Re: Palomino Roofing, 6910 Huseman SW
Request for Permanent C.O. –Accepted
Engineer's Stamp dated: 5-9-07, (M10D016F)
Certification dated: 6-17-14

RE: **Palomino Roofing** – 6910 Huseman Drive SW
Request for **Permanent** C.O. – **Denied**
Engineer's Stamp Dated: 05-09-2007
Certification Dated: 11-04-13

Palomino Roofing, 6910 Huseman Dr. SW

GRADING AND DRAINAGE PLAN
 PALOMINO ROOFING CO.
 6910 HUSEMAN DRIVE SW

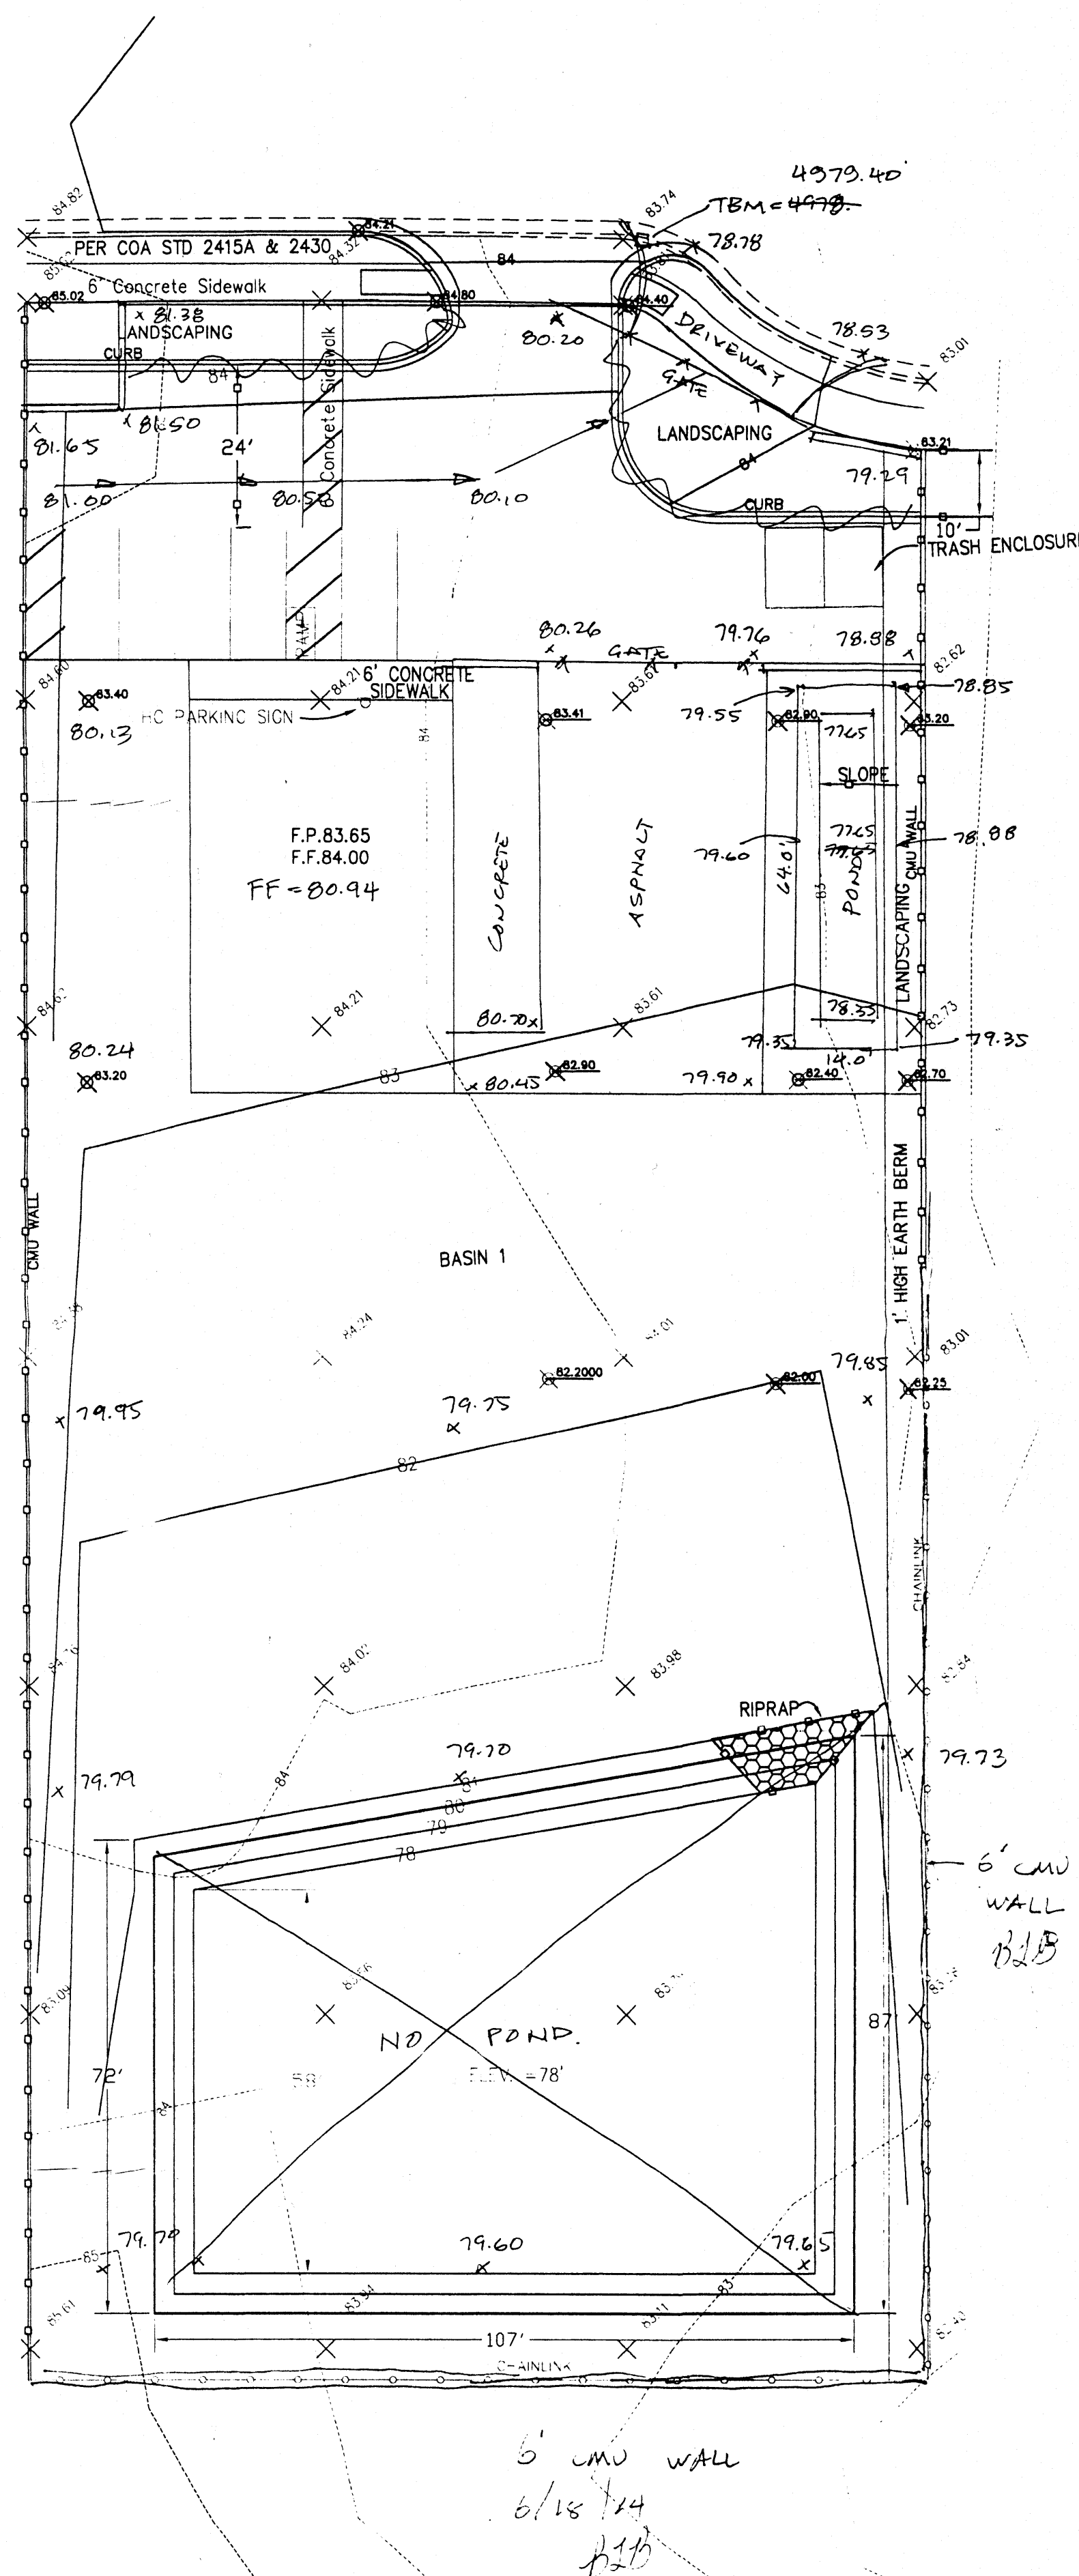
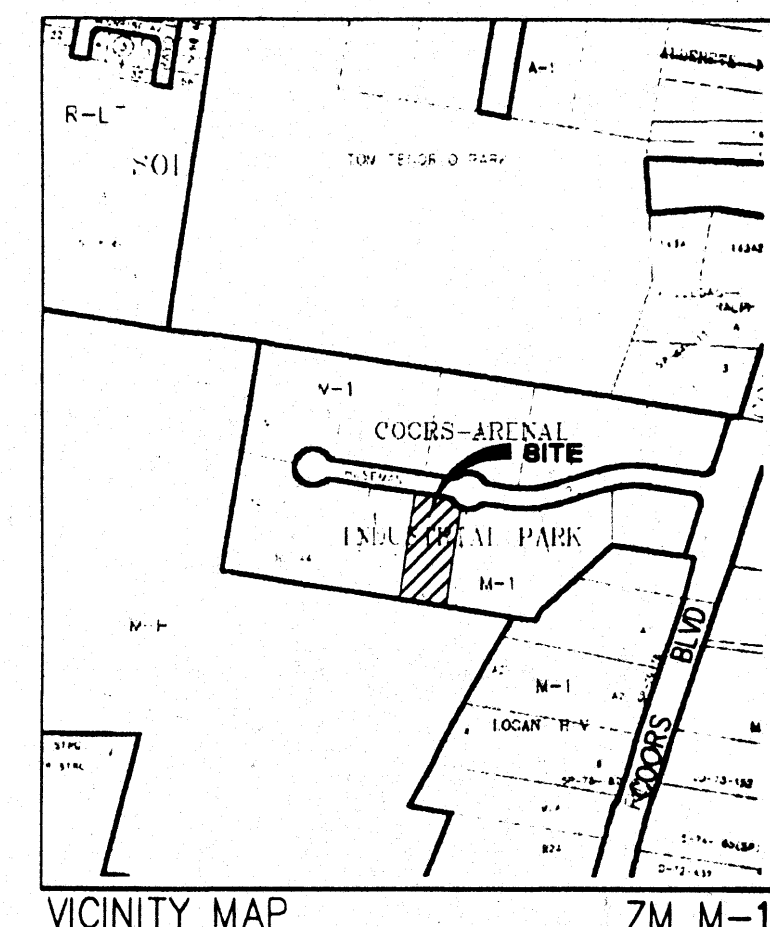
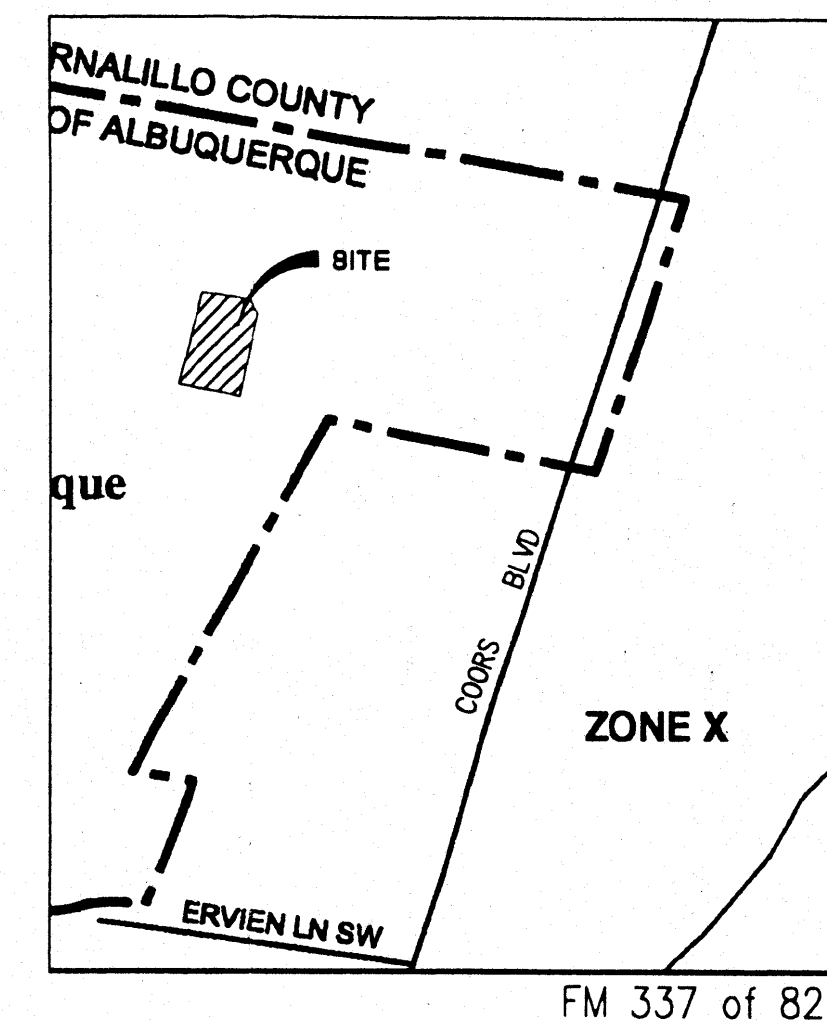
1. The small pond in the NE quadrant of the site is not adequate to provide the calculated, 10-day storm volume required for this developed condition.
2. Based upon aerial photos, it appears that the southern portion of the site is being used as a construction yard, and has been compacted by use to the point of increasing runoff, to a type "C" treatment. This plan inaccurately indicates the area to be "UNDISTURBED." Developed runoff calculations should be revised, if different from the design flows.

3. As-built Pond Volume calculations appear to be based upon the "Water Surface" contour at elevation 83.8 and a pond bottom of 81.77. However, grades shown indicate that the eastern boundary of the pond is part CMU wall and part chain-link fencing, with ground elevations below 83.8. Clarify who the site will retain the required 10-day runoff volume.

4. There appears to be CMU wall along the entire east and south property lines. This plan should indicate as-built conditions, and clarify whether or not the CMU has openings, or if it will retain water.

5. As-built Drainage Certification language needs to include who provided the as-built survey information. Attached below is a copy of the typical, Drainage Certification language that we prefer to see.
